CITY OF ALBUQUERQUE

**RE: GGP Seritage JV Redevelopment
6600 Menaul Blvd NE, Suite 5000
Request for Certificate of Occupancy – Permanent
Hydrology Final Inspection – Not Accepted
Engineer's Stamp Date 7/8/16 (H18D005F)
Certification Dated: 6/15/17**

SHEET NUMBER  
CIVIL 004

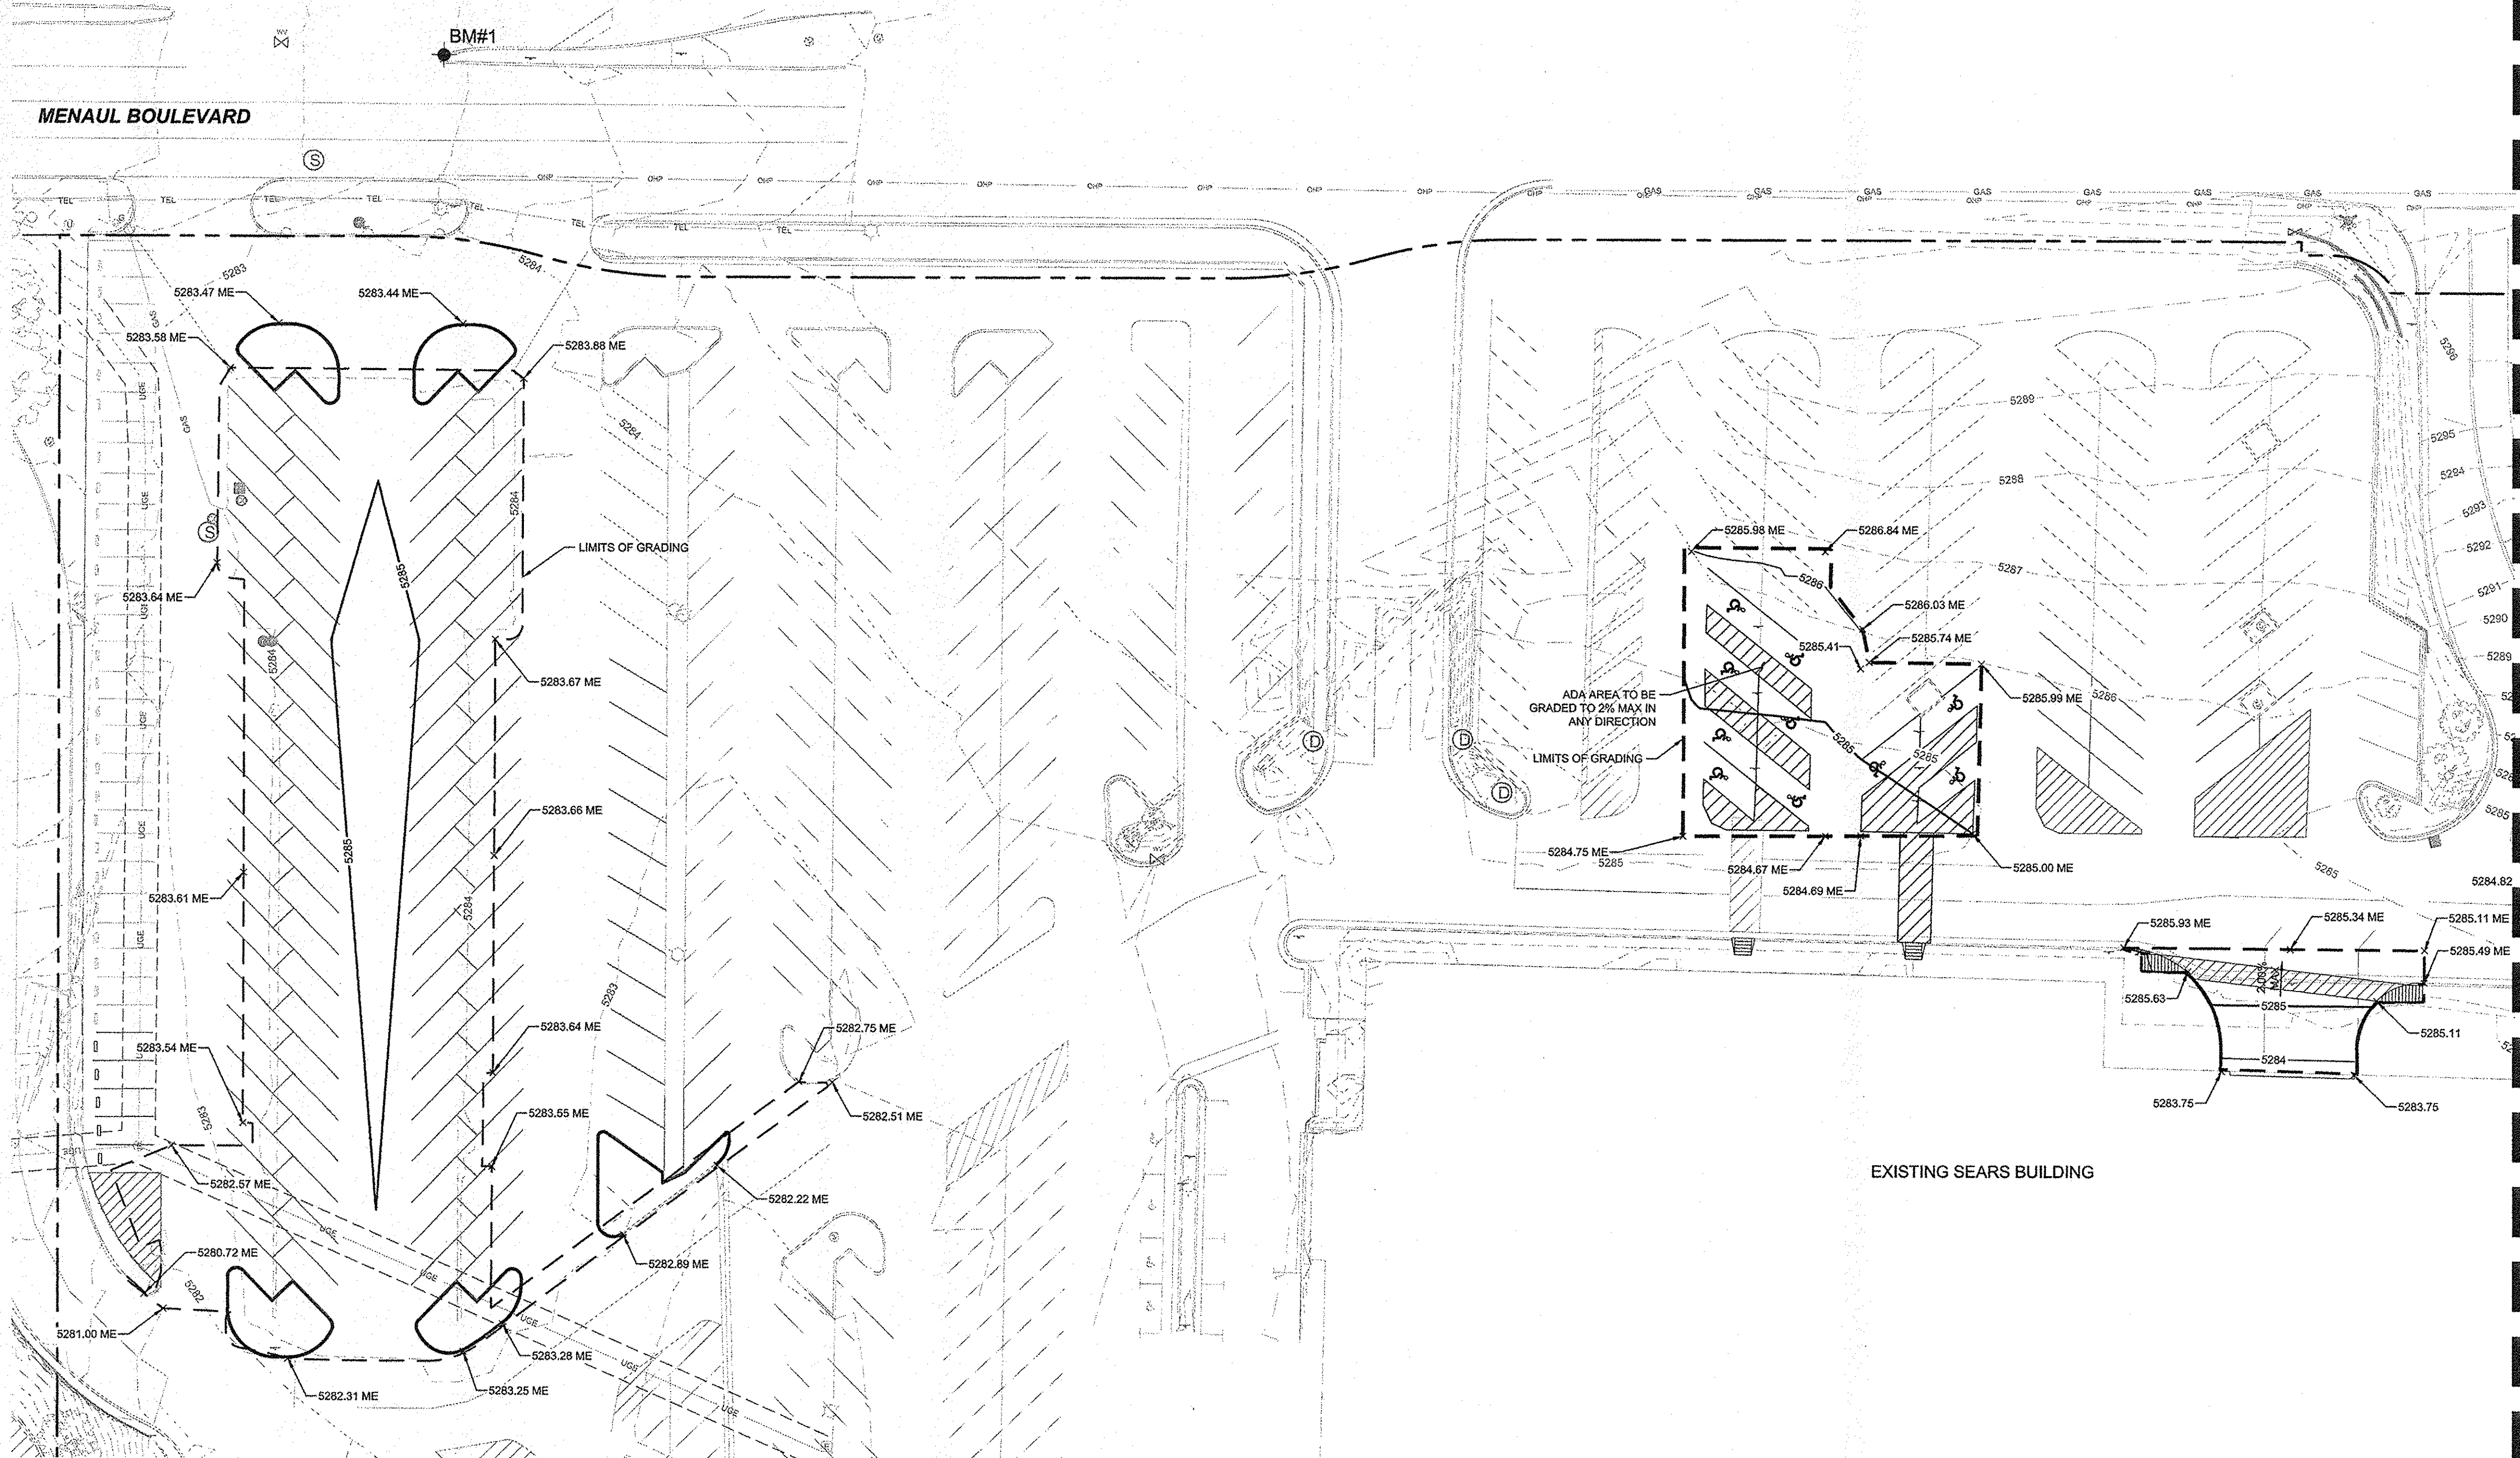
1. The northern dumpster area needs to be contained to drain into the sanitary system. As constructed, the dumpster pad drains out into the drive aisle and to the storm system.
2. The southern dumpster area needs a waterblock to prevent stormwater from draining into it from the drive aisle.
3. As-built survey data is required for the entire site, including both dumpster areas, not just the ADA parking spots.
4. The drainage certification with survey work by a professional surveyor must match the language in the DPM.
